Application by Sembcorp Utilities (UK) Limited for an Order Granting Development Consent for the Proposed Tees CCPP Project

The Examining Authority's Written Questions and Requests for Information (ExA WQs)

Issued on Wednesday 18 April 2018

**Figure E3.1** *Modelled NO<sub>x</sub> Concentrations*

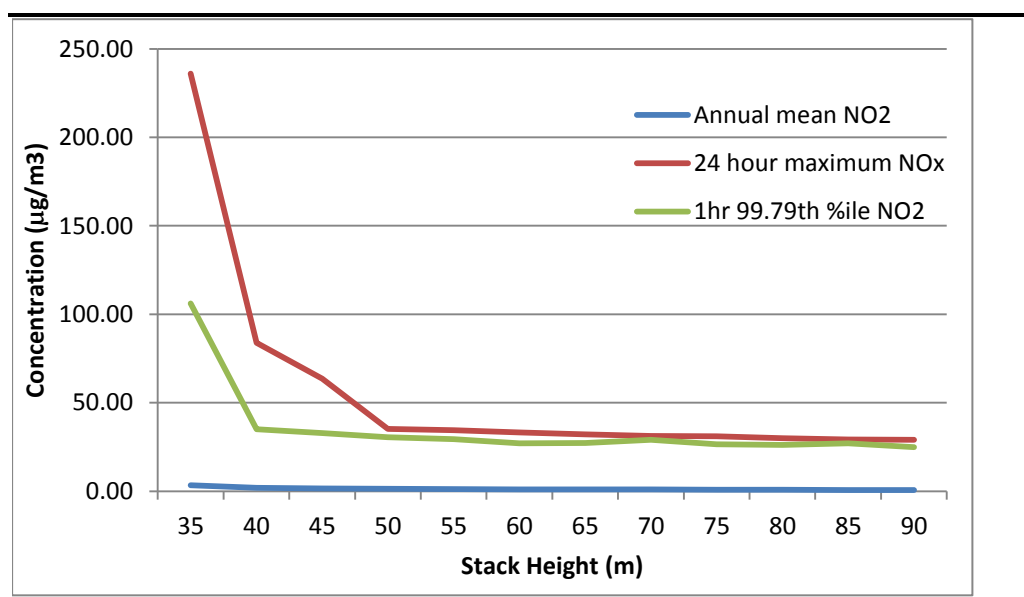
Ref No.	Respondent:	Question:
		<p>Explain how these statements reconcile with paragraph E1.9 of Annex E1 [APP-069] which states that 'the stack height of 75m is the <u>lowest</u> stack height at which impacts on sensitive human receptors are deemed to be acceptable and not significant on ecological receptors' and that the applicant will carry out a further stack height assessment among other assessments as part of the environmental permit process with the implication being that the height could change?</p> <p>Provide an update as to the potential to reduce the stack heights.</p> <p>Without predetermining the application for an Environmental Permit and based on the information within this DCO application, we can agree with the statement that the ES indicates 'the stack height of 75m is the <u>lowest</u> stack height at which impacts on sensitive human receptors are deemed to be acceptable and not significant on ecological receptors'.</p> <p>The stack height could be reduced further, however, this may require the installation and operation of additional abatement equipment to enable the applicant to achieve the Air Emissions Limits (AELs) the Environment Agency will place on these emissions.</p> <p>It is our understanding that the DCO process sets a maximum range for the stack height based on environmental and visual impacts, with a reduced stack height being possible within that range, provided there is sufficient protection of the environment.</p> <p>Whilst the location of the power station units is shown on the layout plans in Figures 5.3 and 5.4 of the ES [APP-047] and on the Works Plan [APP-013] it is not clear where in this envelope the stacks would be located. Why have the locations of the stacks not been fixed within the dDCO, for example by grid reference?</p> <p>Changing the location of the stacks from those given in the air quality model may alter the outcome of the model and therefore the assessment of the environmental impact. The Environment Agency agrees that the location of the stacks should be set, preferably at the grid references used within the</p>

**Figure 7.2** *Indicative Building Layout*

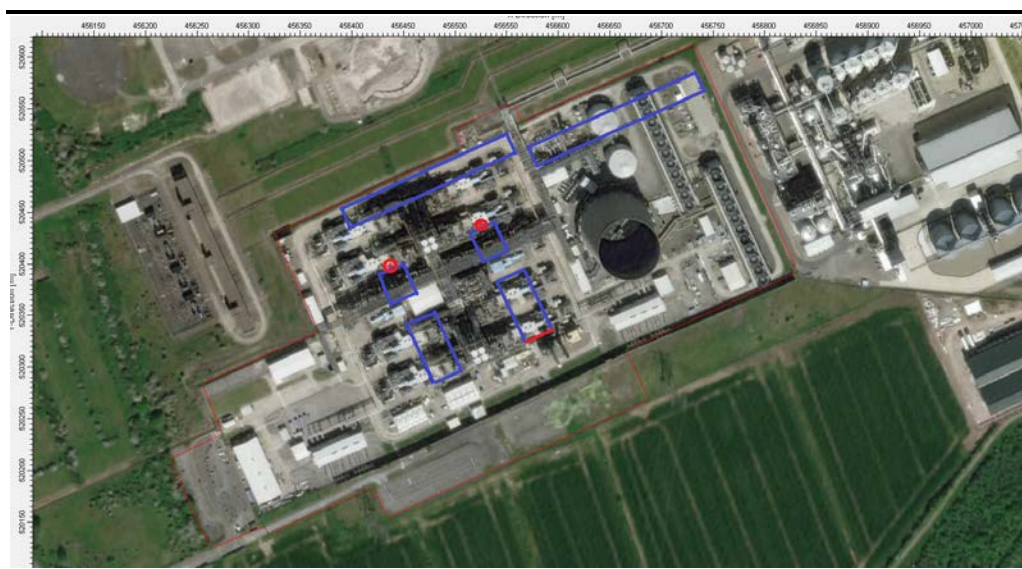
Ref No.	Respondent:	Question:
		<p>air impact assessment source data.</p> <p>Building and stack layout information, used in the Air Impact Assessment model, is provided in Figure 7.2 of the Air Quality report (Volume 1, Chapter 7 dated May 2018 document ref 6.2.7, PINS Ref: EN010082).</p> <p>The Environmental Impact Assessment will be reviewed during the determination of the Environmental Permit and if agreed, the plant will be built in accordance with that application, thereby fixing the stack locations.</p> <p>What assumptions have been made in the relevant ES assessments on the location of the stacks, noting that their location is not defined within the Works Plans for dDCO? This should include confirmation of what stack locations have been assumed as part of the air quality modelling (and HRA Report) in respect of a 'worst case' scenario.</p> <p>Table 7.5 of the ES [APP-049] indicates that the diameter of the stacks would be 8m. How would the final diameter of the stacks be determined? Would this be through the environmental permitting process?. Please explain why the diameter of the stacks has not been specified in the dDCO.</p> <p>The stack diameter is specified in Table 7.5 of the Air Quality report (Volume 1, Chapter 7 dated May 2018 document ref 6.2.7, PINS Ref: EN010082) which also states that 'no sensitivity testing for stack diameter was undertaken on the basis that the diameter is optimised to avoid back pressure issues.'</p> <p>The stack diameter will be stated in the application for an Environmental Permit as part of the Air Modelling Source Data which will be assessed during the Environmental Permitting Process. The stack diameter will be assessed during the determination of the environmental permit in so far as it is one of several figures used as input data in the Air Emissions Impact Model.</p> <p>The previous power station located on this site had 8m diameter stacks and it was extremely difficult</p>

Figure 1 - Tees CCPP High Level Layout

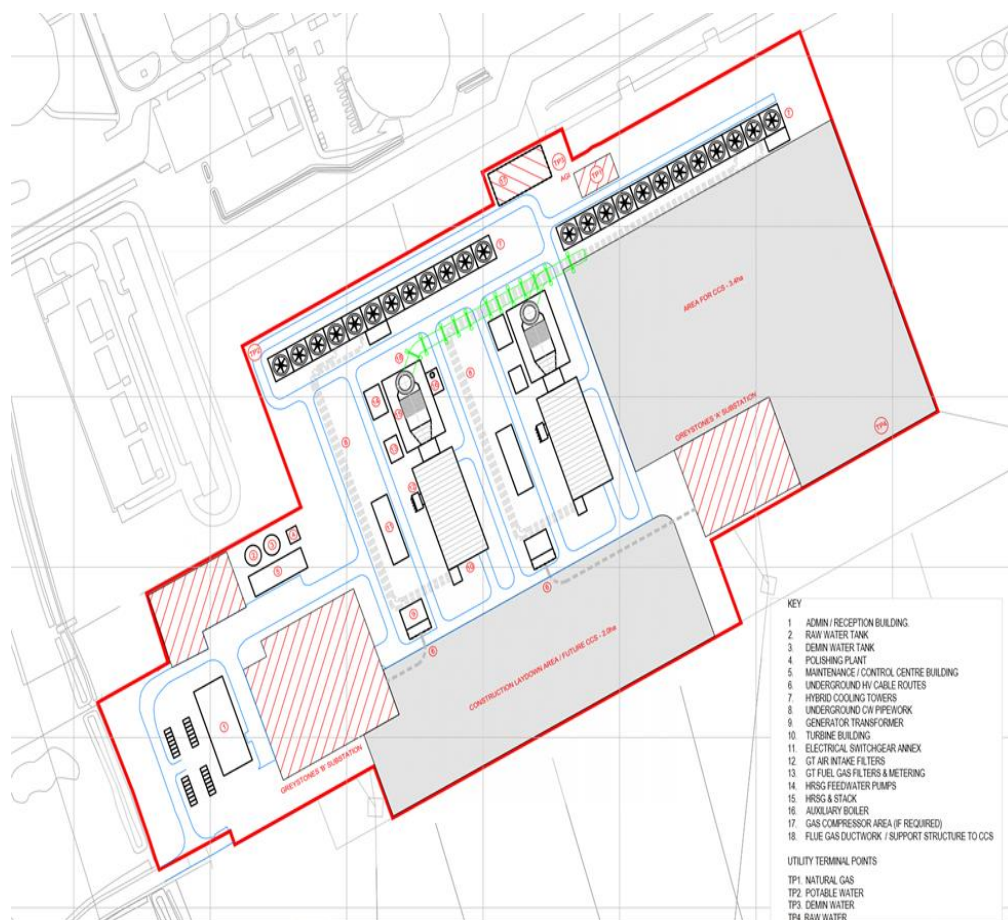
<p>7 Infrastructure</p>		
<p>Q1.7.5</p>	<p>Applicant Environment Agency</p>	<p>Paragraph 4.21 of the Carbon Capture Readiness (CCR) Statement [APP-039] indicates that an 8 hectare site for CCR would be required based on International Energy Agency estimates. Paragraph 4.22 goes on to estimate that based on other studies the requirement may only be 4.6 hectares. The area available for CCR at the application site is 5.4 hectares.</p> <p>Does the fact that the total area of 5.4 hectares is split between two areas create any difficulties?</p> <p>The applicant has not provided a plan showing the proposed locations of the key CCP features therefore we are unable to provide an opinion on this matter. As outlined below, we have concerns about the size of the area for CCR.</p> <p>What further reassurance can be provided that this area would be adequate for CCR?</p> <p>The Environment Agency cannot comment on the proposed CCR footprint of 5.4 ha without additional</p>

Ref No.	Respondent:	Question:
		<p>evidence that the CCP will fit into the space allocated. The information required in Annex C of the DECC CCR (2009) guidance is therefore required. Please refer to the Carbon Capture and Storage Section in our written representations letter.</p> <p>The DECC Carbon Capture Readiness 2009 guidance states: <i>Applicants should submit the required assessments demonstrating CCR as part of their initial Section 36 consent application with its supporting documentation. The assessments should not be considered supplementary information which can be submitted at a later stage. Together with the rest of the Section 36 application material, these assessments will be public documents. This guidance also explains the level of information which applicants can reasonably be asked to submit in the demonstration of CCR when applying for Section 36 consent.</i></p> <p>The information required by Annex C, DECC CCR (2009) should be submitted at the DCO application stage to feed into decisions about plot size, location and orientation.</p> <p>An approach taken at another plant involved engaging the services of Florin and Fennel, to review their technical CCR proposals and to write a report confirming whether they considered the space available and the design was feasible. The EA accepted this report as part of the DCO consultation process. This approach should be considered by the applicant.</p>
